**CWWTPR DCO Examination**

**Submission by Save Honey Hill Group 6 December 2023**

**SHH 28 SHH Comments on Applicant’s Responses to ExA’s ExQ1 REP1-079**

Viewpoint 22: Residents of Poplar Hall and Poplar Hall Farmhouse looking south, residents of Red House Close looking north and users of Footpath Fen Ditton 85/6

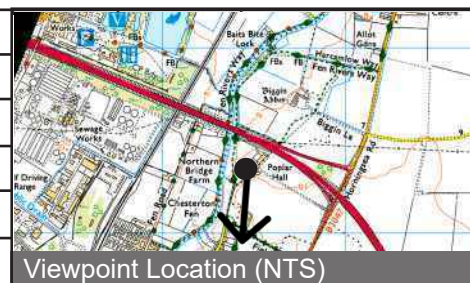
7.9	SHH questions that access to Poplar Hall and Poplar Hall Farm would not be affected and also believes that access to Biggin Abbey and Biggin Abbey residences will be.
